From: Sue Howell <Sue.Howell@arun.gov.uk>
Sent: 28 January 2021 17:32
To: Planning.Responses <Planning.Responses@arun.gov.uk>
Cc: Raymond Cole <Raymond.Cole@arun.gov.uk>
Subject: Planning Consultation on: BN/142/20/OUT

Response to Planning Application

Application ref: BN/142/20/OUT

Description: Outline planning application with all matters reserved, other than principal means of access, for up to 200 No. dwellings, with access taken from Marshall Close, associated infrastructure & landscaping & demolition of existing buildings. This application is a Departure from the Development Plan, may affect the setting of listed buildings, may affect the Church Lane, Barnham Conservation Area & affects a Public Right of Way.

Illustrative site layout plan

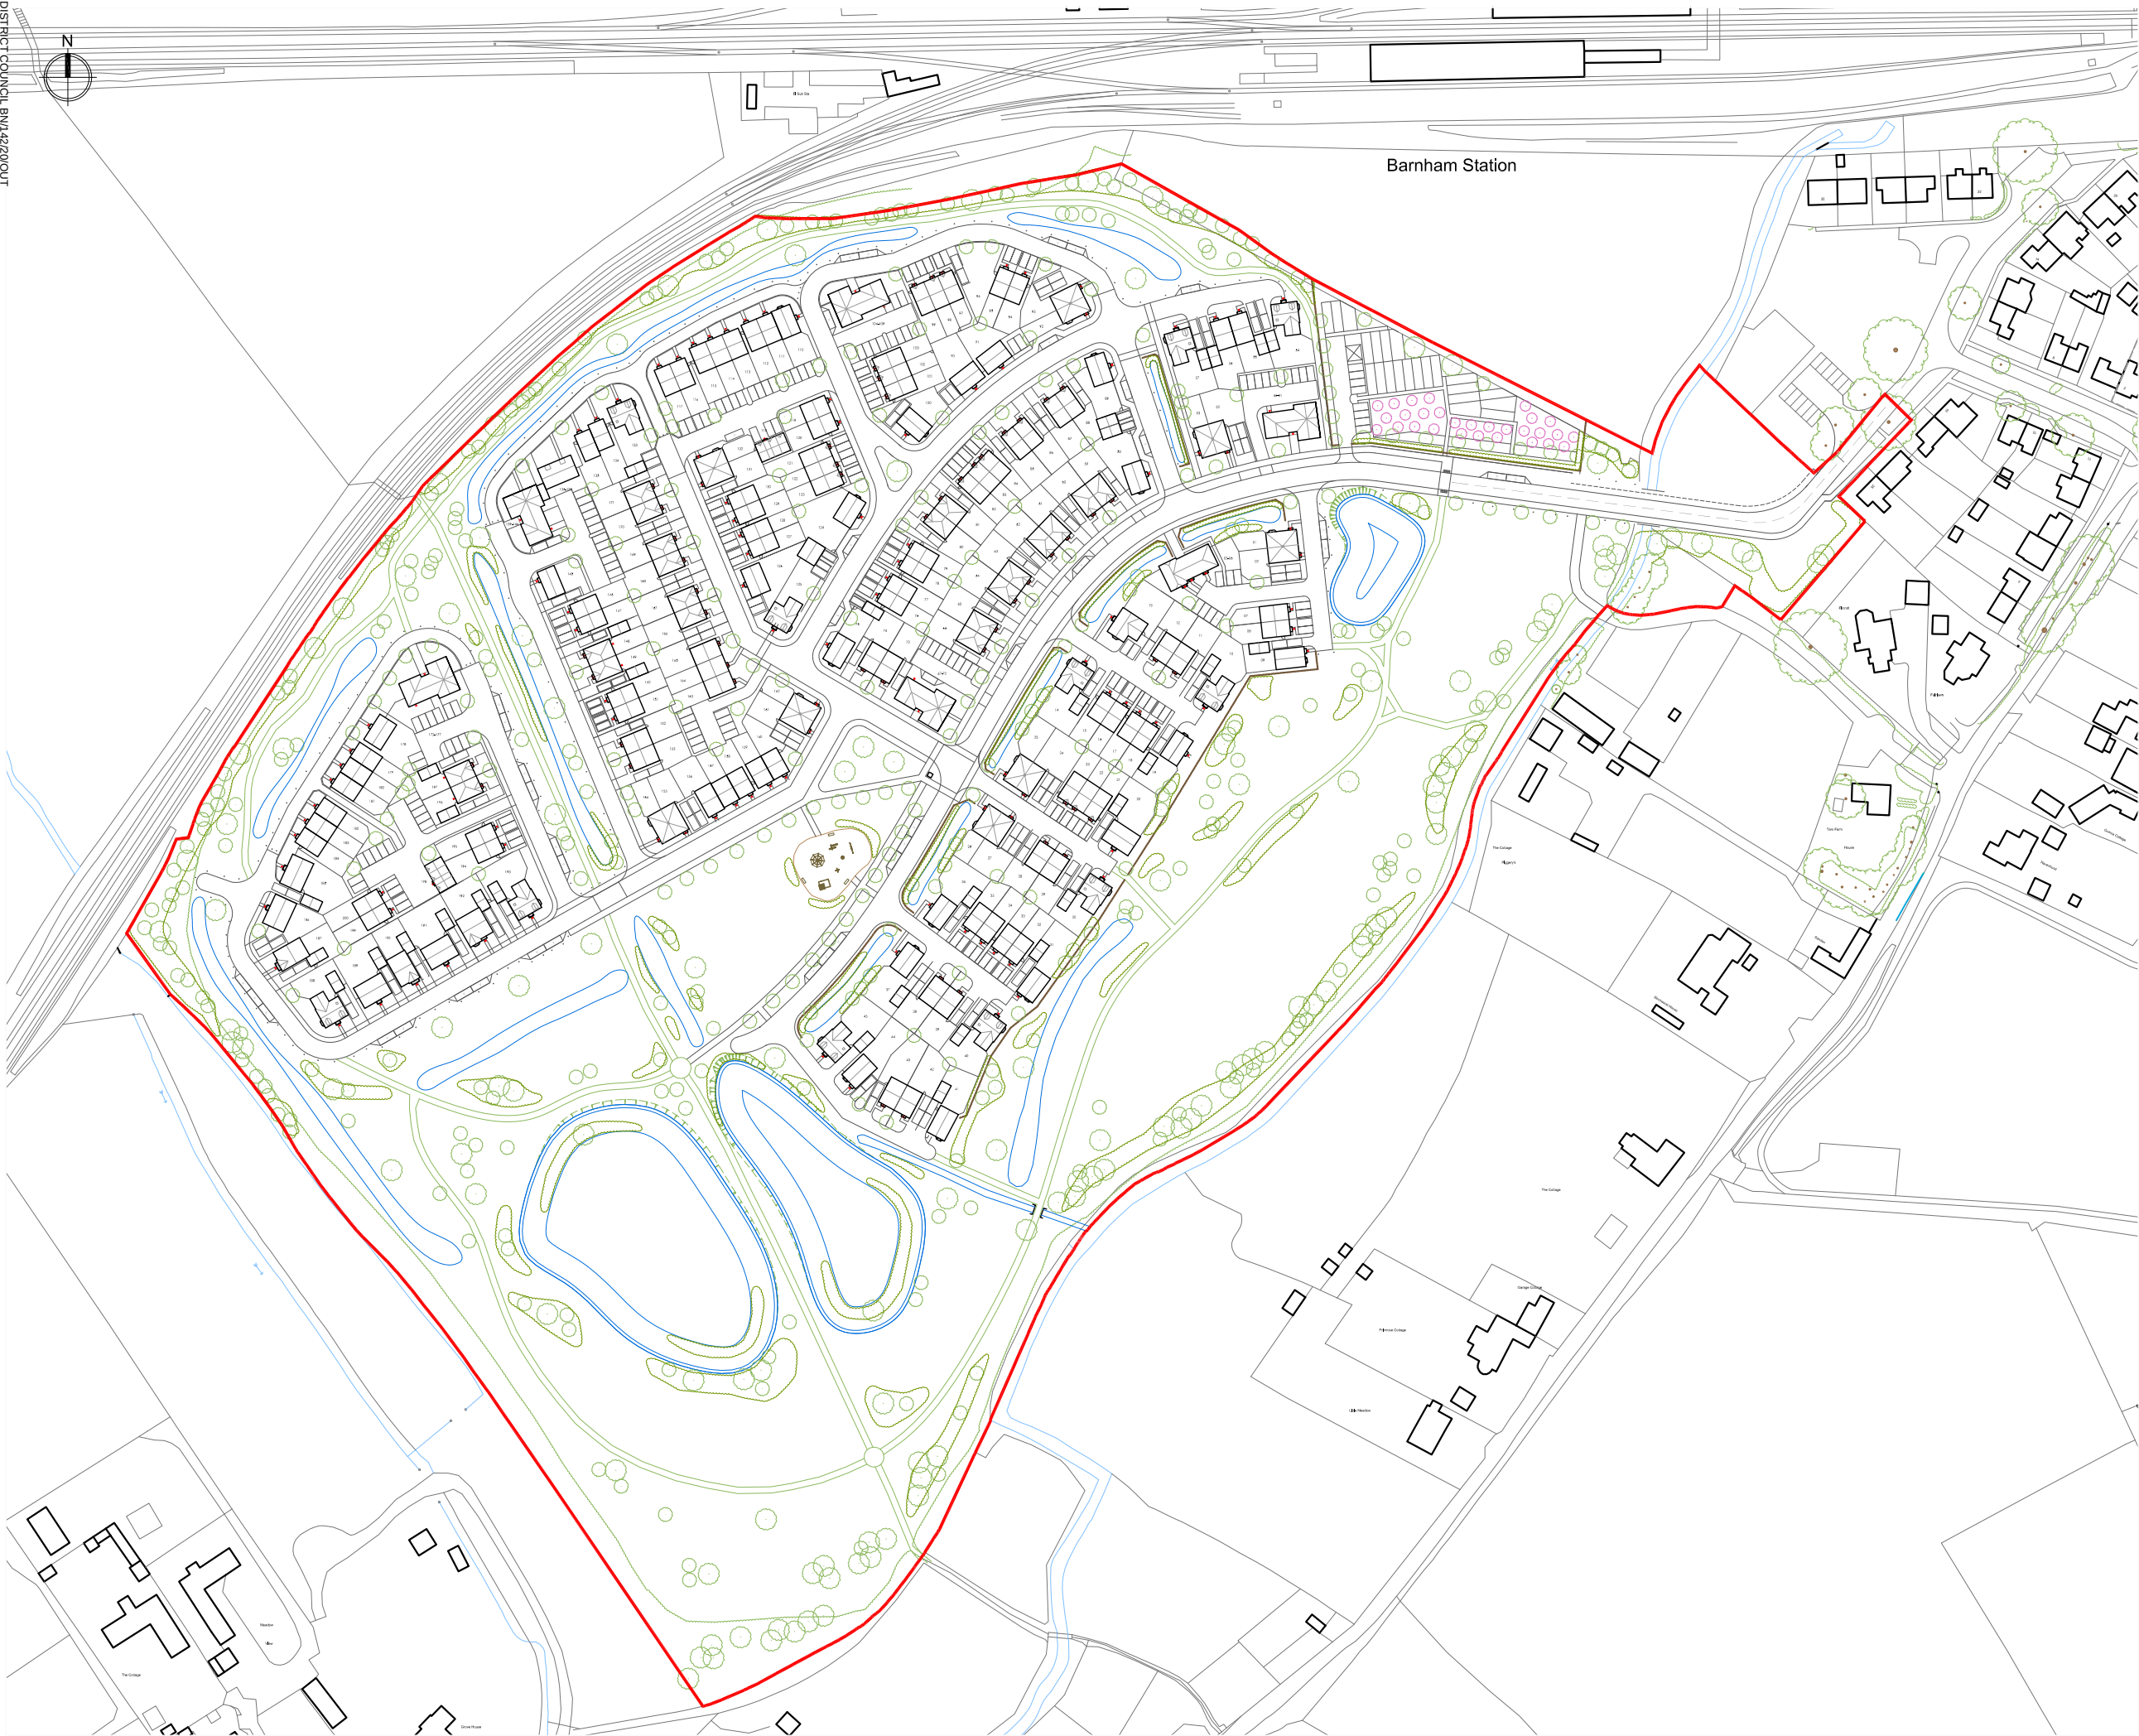
This proposal for this site is for residential development of up to 200no dwellings. The information provided within the Illustrative Site Layout 1311.03 indicates a significantly sized development with good areas of POS surrounding areas of housing. The limited detail submitted with this application indicates areas of POS which would appear to cater for the existing trees and hedges along the western and southern boundaries where some significant and worthy of retention trees and hedges are located. There would not appear to be a significant canopy cover in general across this site, but of note in particular are 3no significant individual Oak Trees on the southern boundary which are worthy of retention and must be protected and retained. These have the potential to become veteran trees and are contributing hugely aesthetically and to wildlife habitat in this location.

Quality, well-designed Public Open Space will be fundamental to any proposal submission, these will need to accord with Arun District Councils OS SPD January 2020. There would be requirement for confirmation of the areas of public open space being proposed with this development, and clarification re quantum. The Illustrative site layout shows where these could be located and also of note indicates substantial SuDS

features within these areas. The quantum of POS being proposed for this development would need to be confirmed. Our SPD January 2020 would require 16,500m² as a minimum of well connected, usable, quality POS provision within this development.
